Your Ref: 000014323
Our Ref: WA/72/12/ 21-11-2012
Please ask for:
Mrs S Leeson

2nd January 2013

Revisions to previous approval WA/66/11 for the proposed refurbishment works to the Holly Tree pub including 4 no. bed & breakfast rooms
The Holly Tree Public House The Street Walberton

NORTH WEST ELEVATION AS PROPOSED

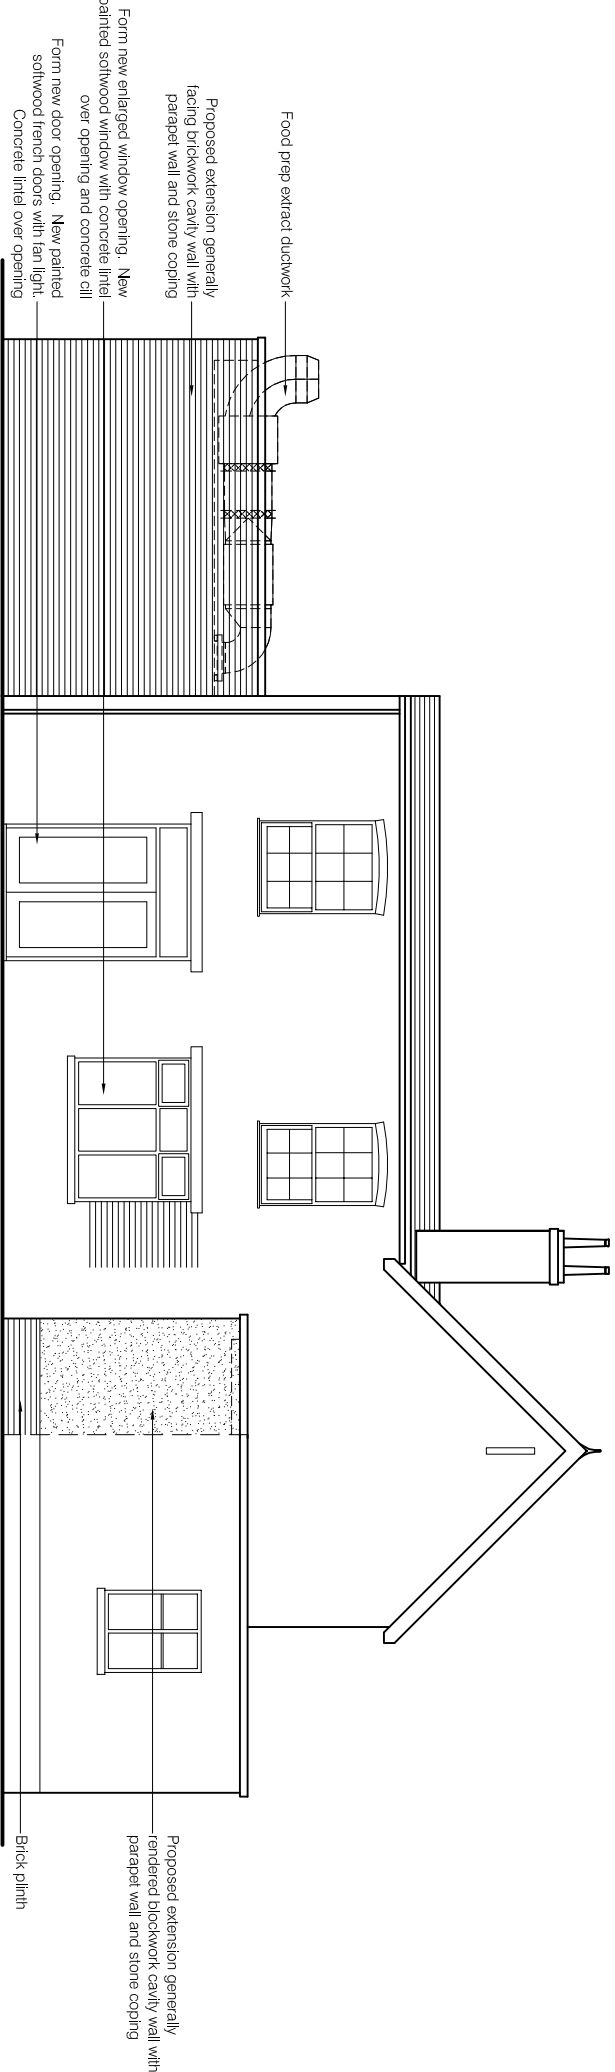
The Sussex Pub Company has an excellent local reputation and a business model that suits The Holly Tree Pub very well and one that I am delighted to support. However, in order to ensure that the new terrace on the west side of the pub does not impact on the neighbours privacy, screening provision should be included eg by heightening existing boundary wall.
